Item No. **Report of the Head of Planning, Transportation and Regeneration**

Address 97 EASTCOTE ROAD RUISLIP

Development: Erection of a part single storey, part two storey rear extension, erection of a porch, plus 2 x side high-level ground floor veluxes to light utility room and hallway; obscured side window.

LBH Ref Nos: **69526/APP/2022/1556**

**As Proposed**  
Elevations

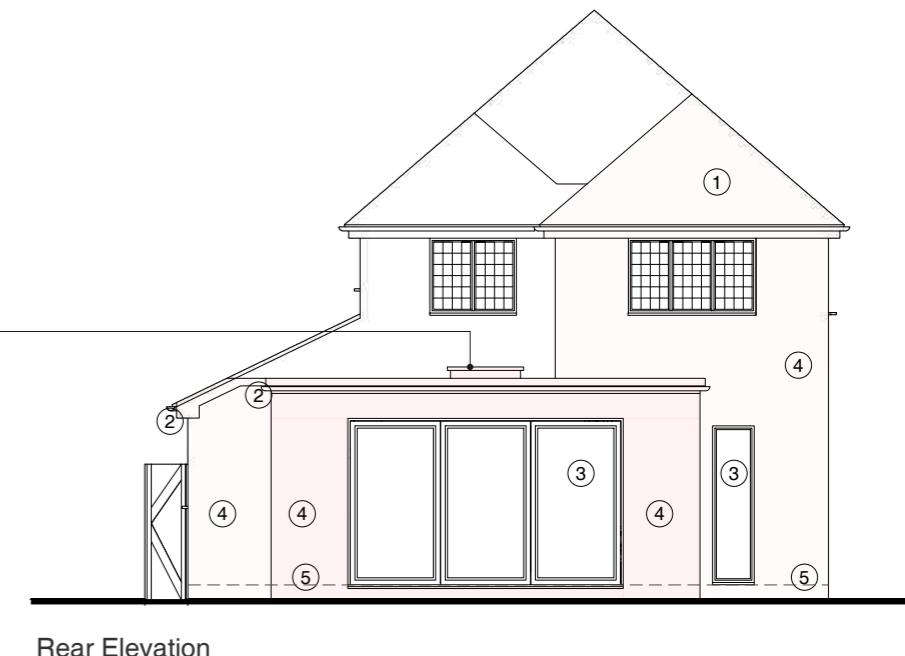
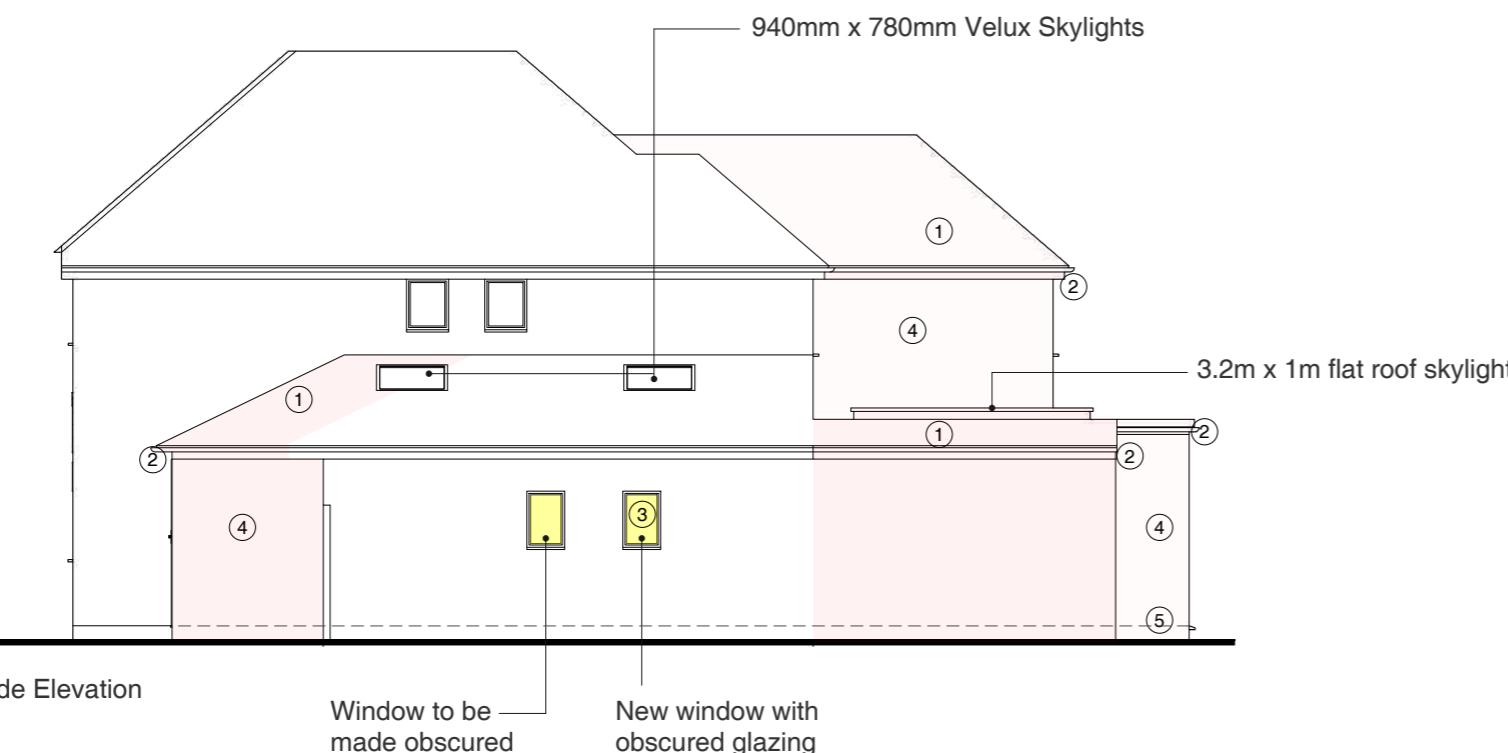
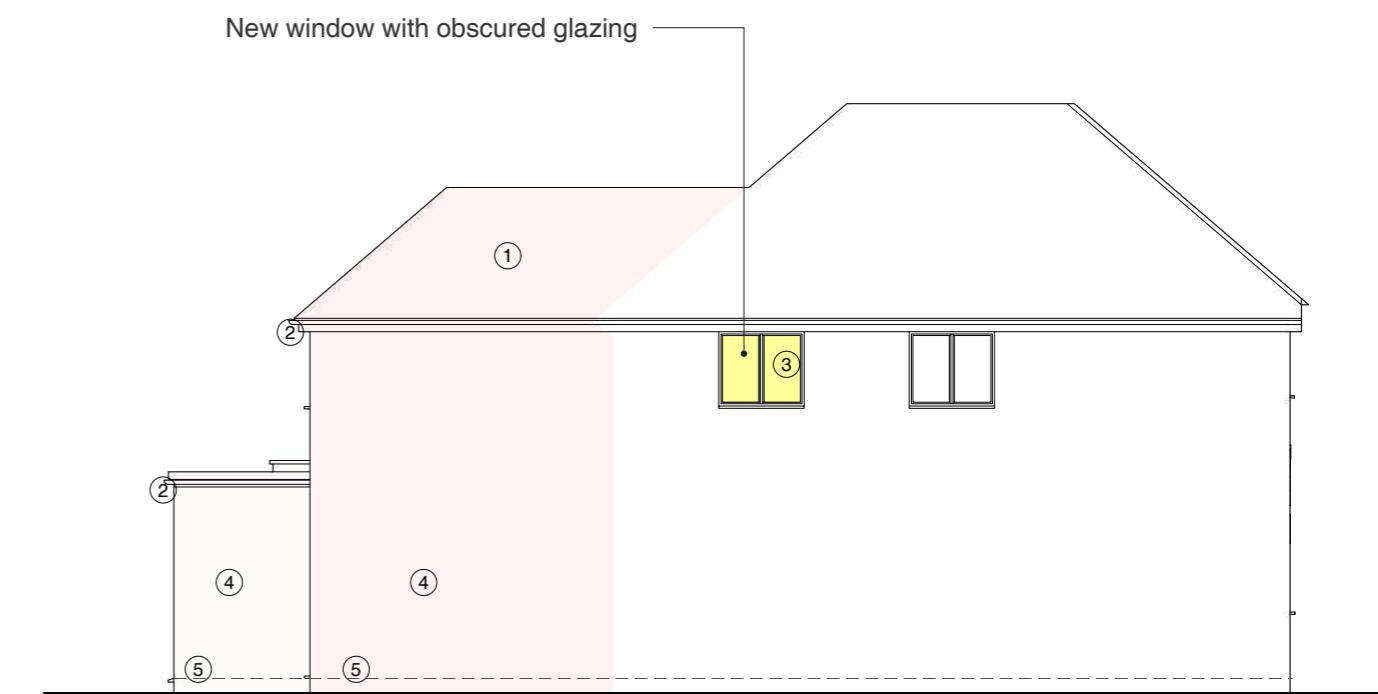
The proposed rear extensions project 3.99m at first floor level with an additional 1.8m ground floor addition to the rear in the centre of the property. Whilst not fully compliant with the requirements of Policy DMHD1, the proposed rear extensions would appear subordinate in scale and would respect the architectural integrity of the host dwelling. The proposed extensions to the rear would not be out of keeping with other properties within the area. Notably Numbers 99, 101 and 103 Eastcote Road have all had two storey and single storey rear extensions. The proposed rear extensions are not therefore considered to result in visual harm to the locality.

The proposed extensions to the rear would not breach the 45 degree line from first floor windows of both adjacent properties at numbers 99 and 95 Eastcote Road. The additional rearwards bulk is not considered to give rise to an undue loss of light or outlook. The proposal includes the insertion of 1 first floor side facing window to serve bedroom 2 facing 95 Eastcote Road. This window is a secondary window and is shown to be obscure glazed. A condition would be reasonably required to retain this obscure glazing to ensure no undue loss of privacy to the occupants of Number 95. Two ground floor obscure glazed windows are also proposed facing Number 99 Eastcote Road which would not result in an undue loss of privacy.

The first floor bedroom window facing 95 Eastcote Road and two ground floor windows facing number 99 Eastcote Road shall be glazed with permanently obscured glass to at least scale 4 on the Pilkington scale and be non-opening below a height of 1.8 metres taken from internal finished floor level for so long as the development remains in existence.
